Rosefield Solar Farm

Applicant's Response to Deadline 5 Submissions

EN010158/APP/8.42
Revision 01
Deadline 6
August 2026
Rosefield Energyfarm Limited

Figure A.1: Analysis elements within the 10km study area

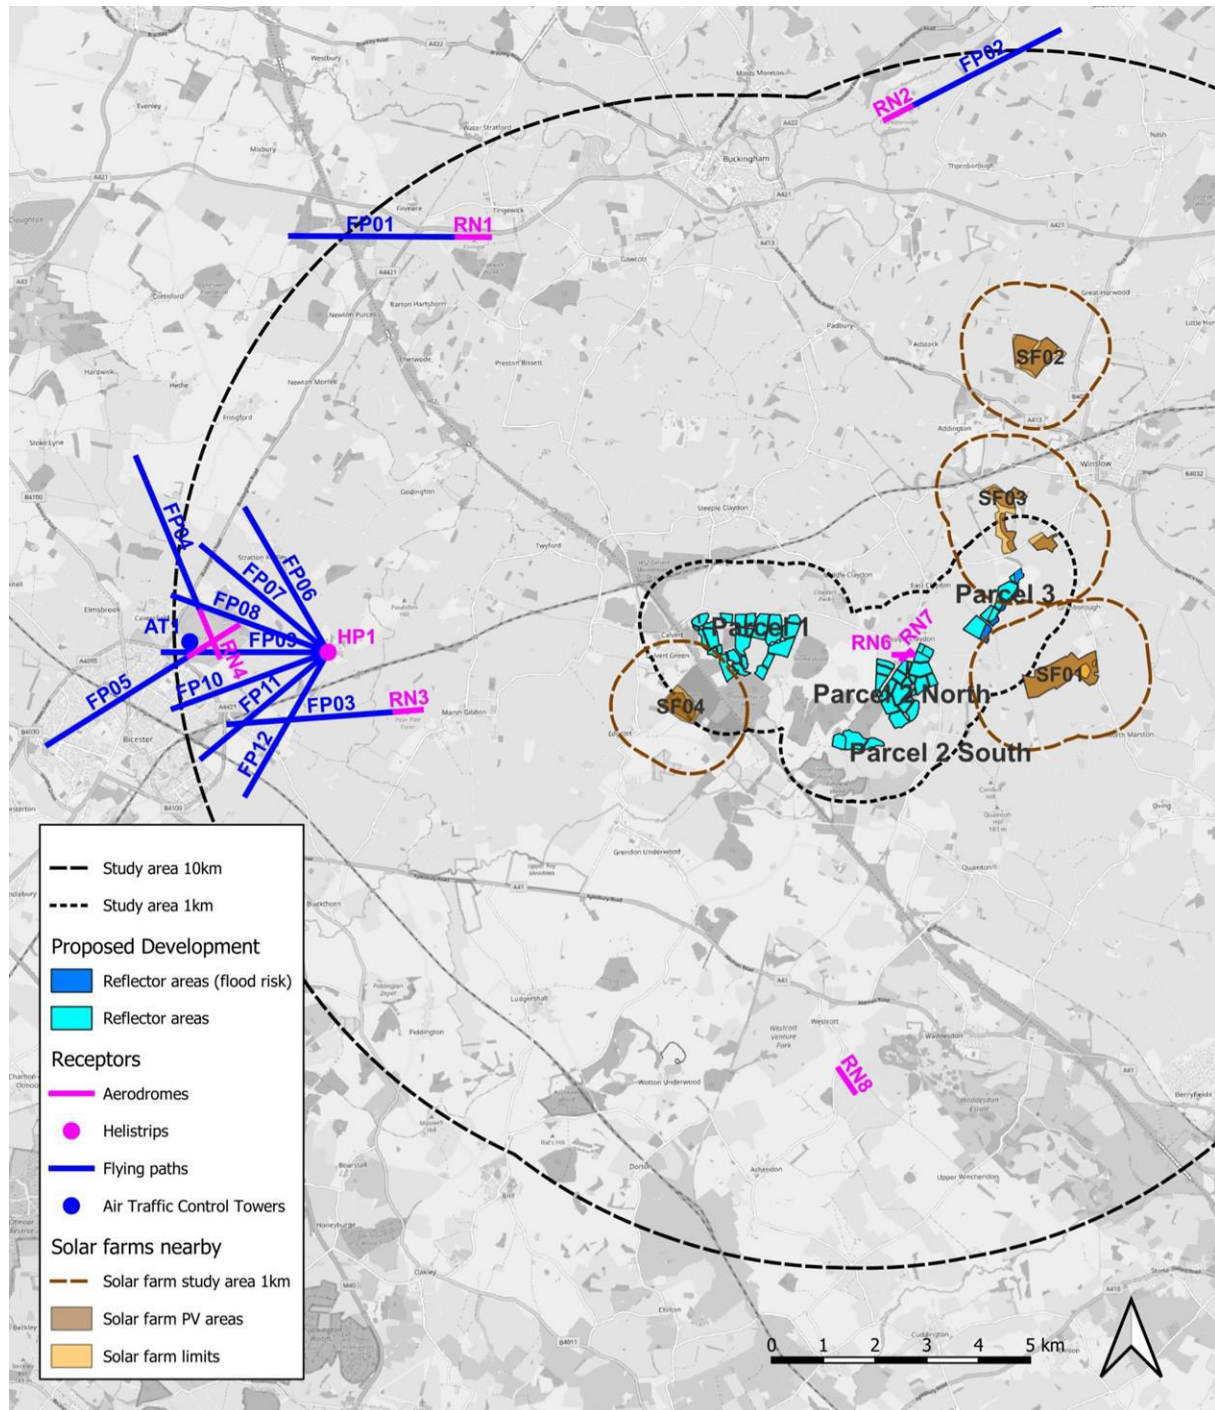
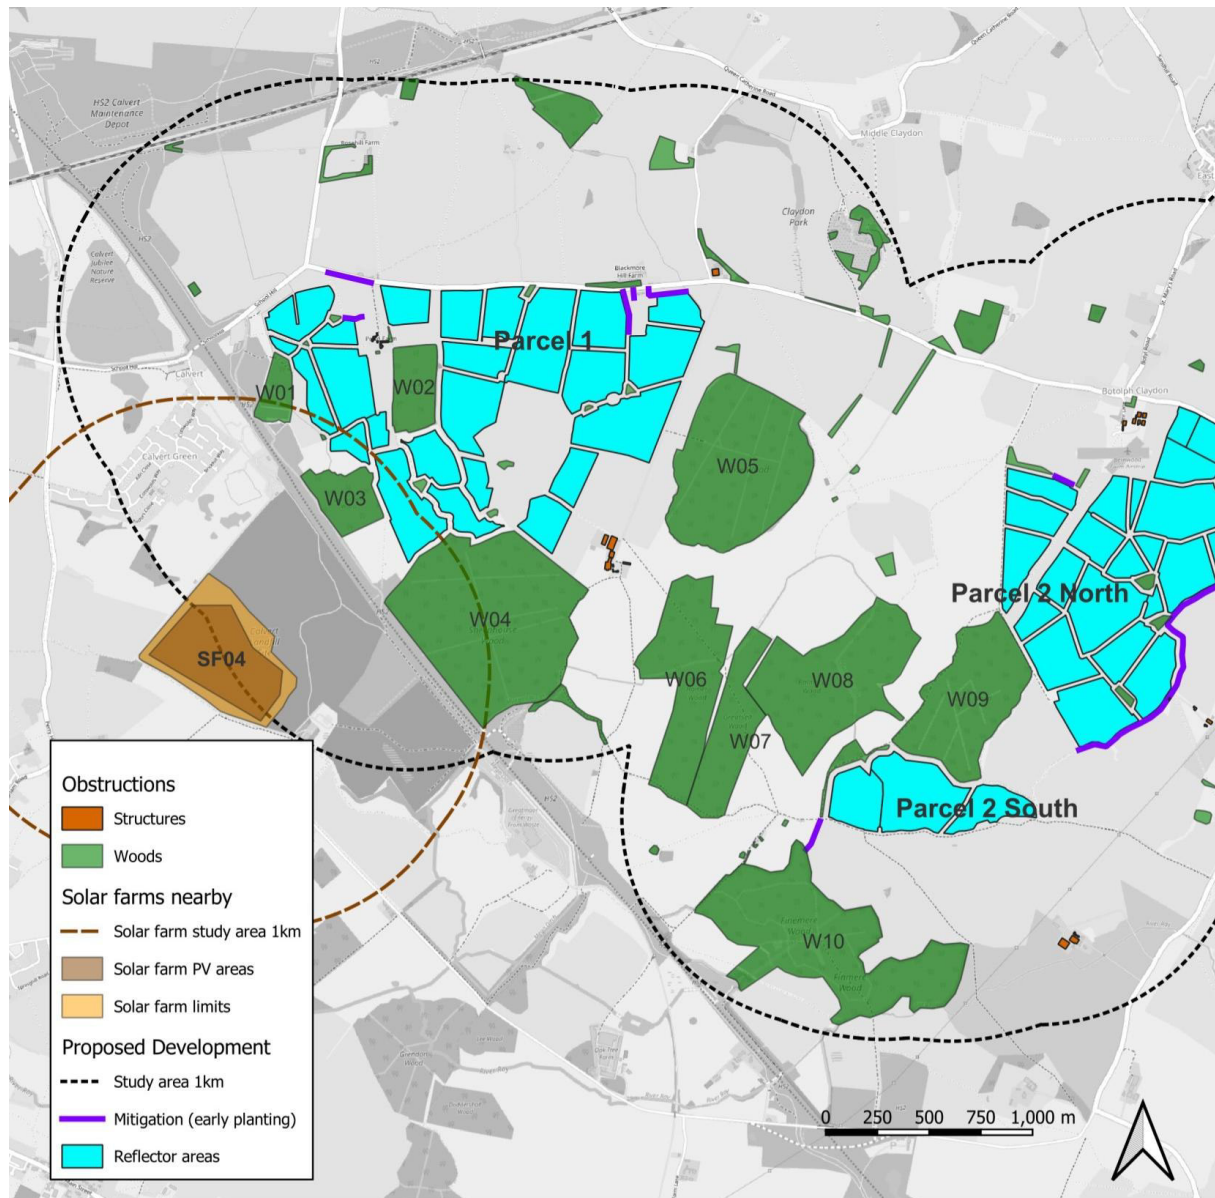
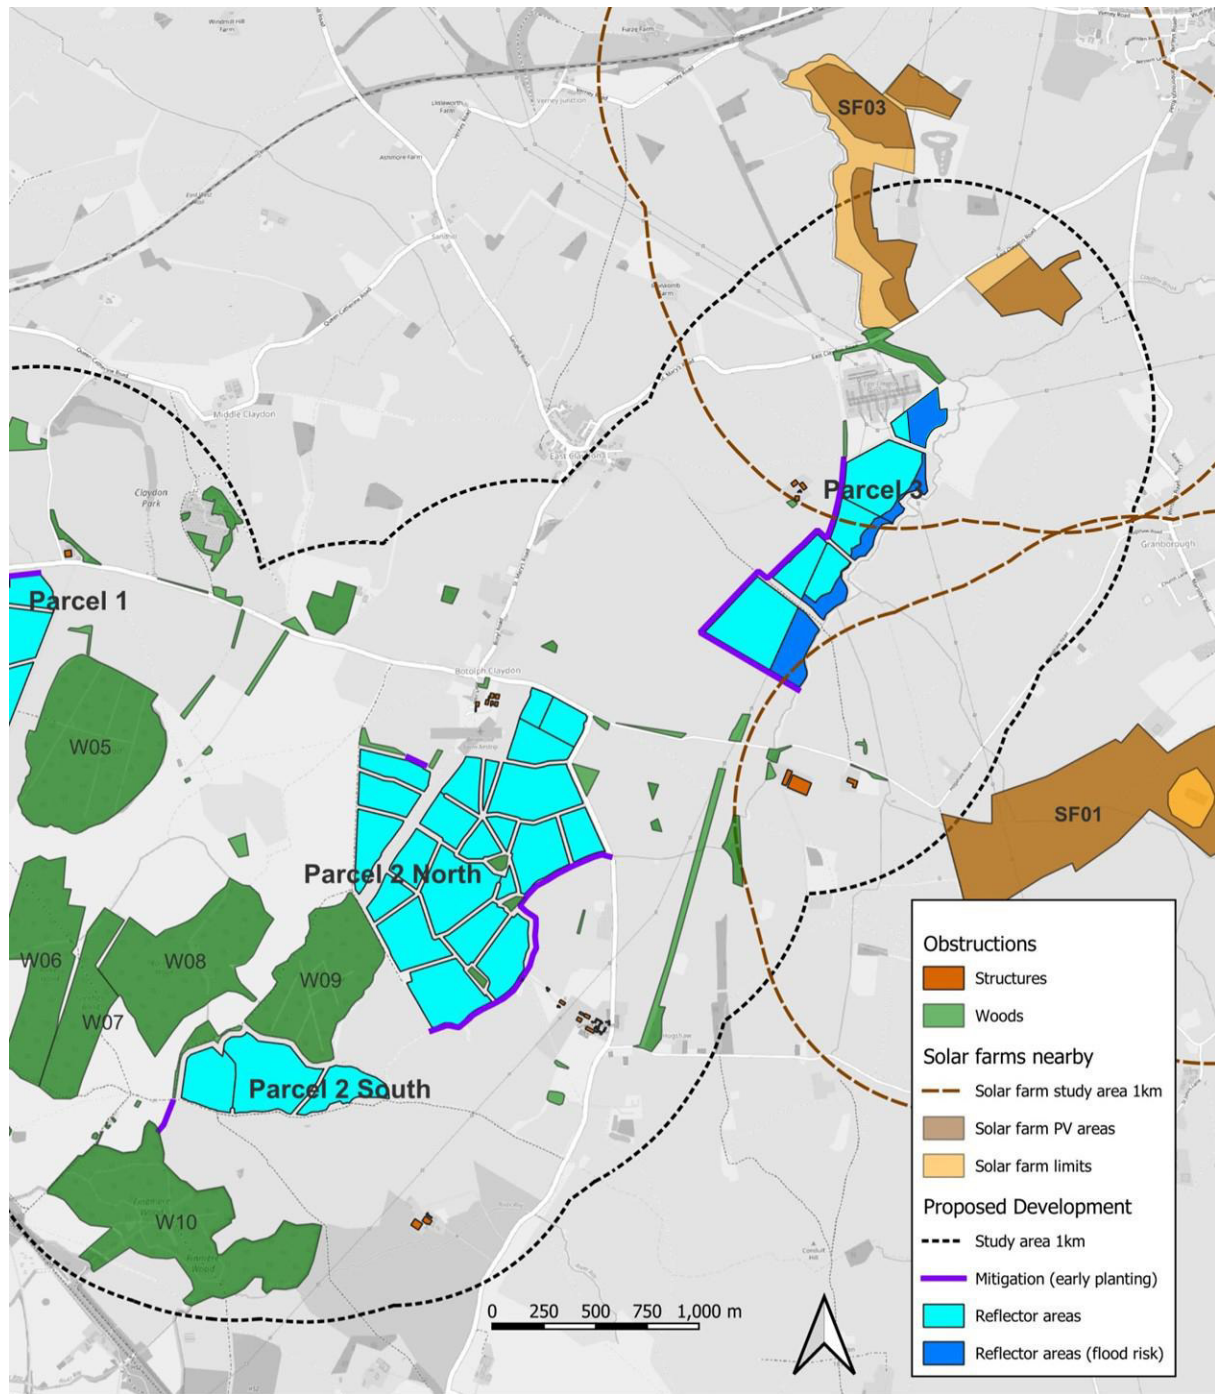
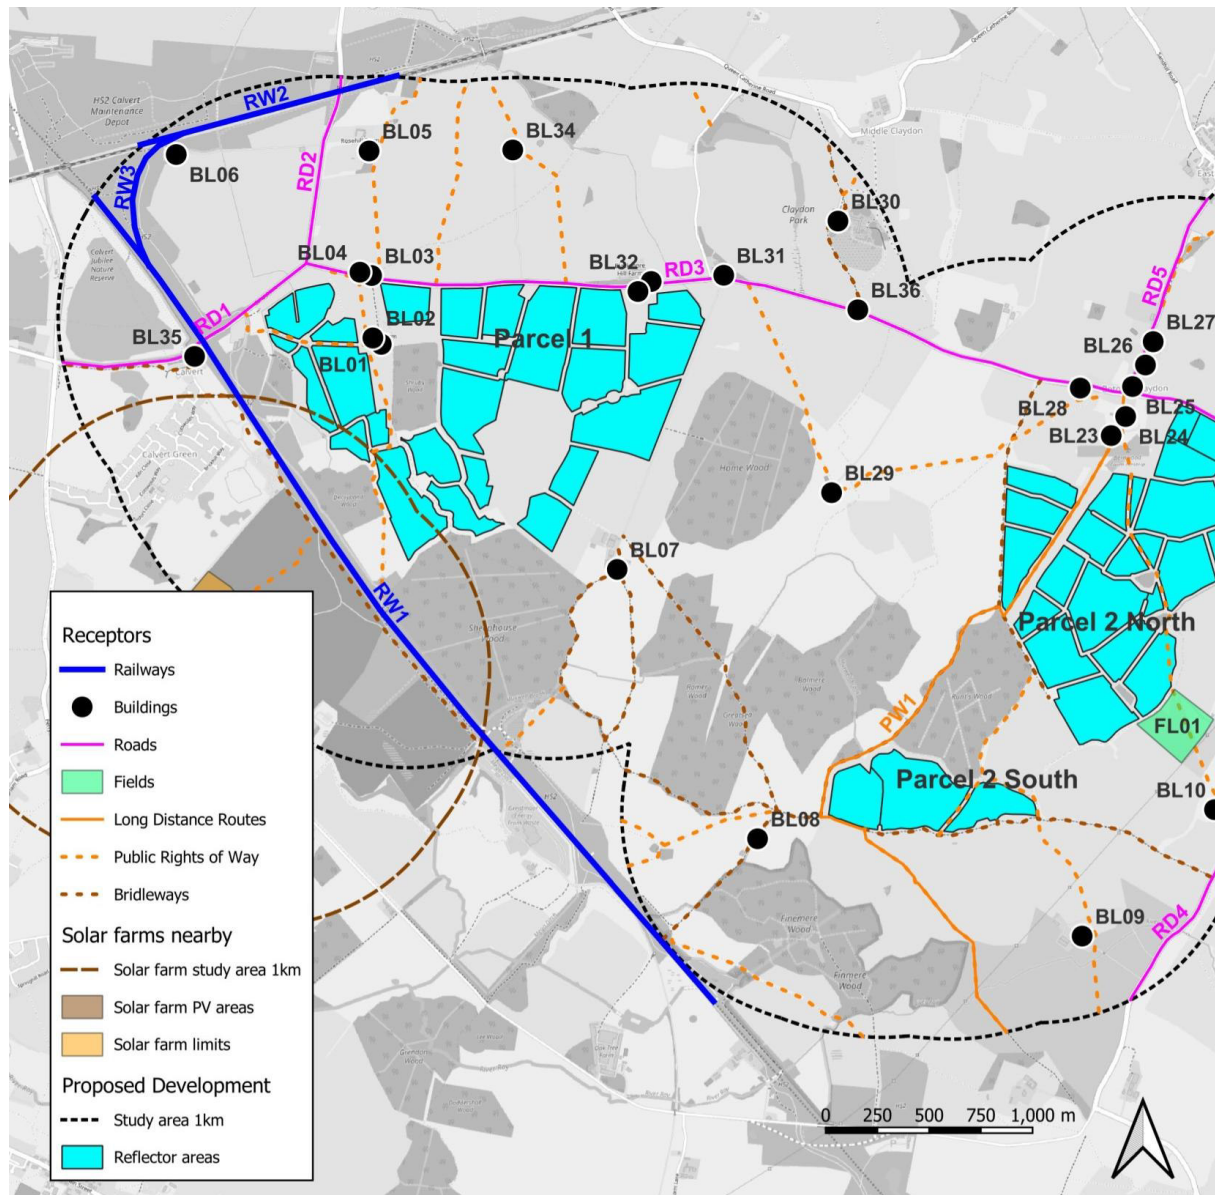
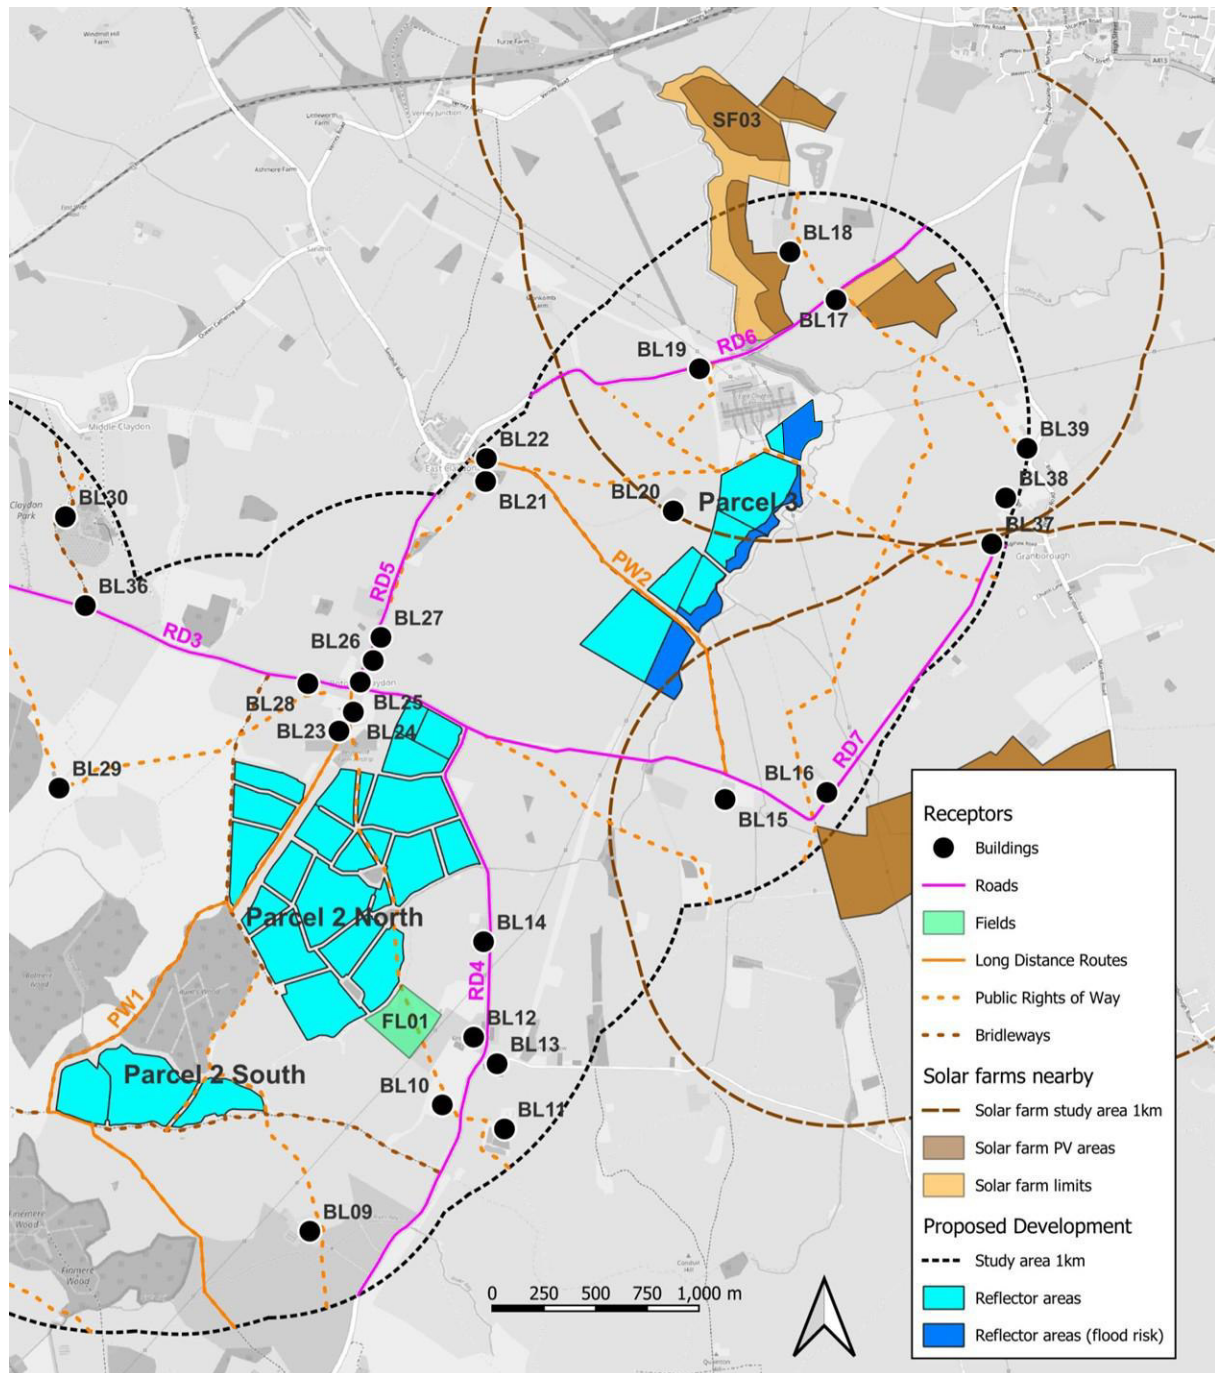
3.11	CSAG [REP5-109], epage 142, Paras 4.11 and 4.12	Comments noting concern over ‘informal’ method used in the Glint and Glare Assessment. Further comment that the LVIA should consider the effects of glint and glare in particular locations / for specific landscape and visual receptors as they consider that it is likely to adversely affect people’s experiences of being in or travelling through the landscape.	As set out in ES Volume 4, Appendix 5.4: Glint and Glare Assessment [EN010158/APP/6.4.2] [REP5-045], in the absence of a published official methodology for Glint and Glare assessment, the analysis is based on industry’s best practice and guidance: “Solar Photovoltaic Glint and Glare Guidance” (Fourth Edition, September 2022). The vast majority of Glint and Glare assessments in UK (if not all) refer to this formal guidance, and the Applicant rejects the assertion that its method is “informal”. The conclusions of the analysis are also based on this piece of guidance. Adverse glint and glare effects on people’s experience are not unexpected where solar reflections are visible. However, the analysis demonstrates that these effects will be negligible or minimal, and they will not significantly increase the risk of an accident or alter the enjoyment of the landscape. The analysis is limited to receptors where significant impacts are considered possible. Further commentary is, therefore, not included in the LVIA as glint and glare effects are judged to be no more than low for people in the study area and any such effects would not change the assessment of effects already described within the LVIA.
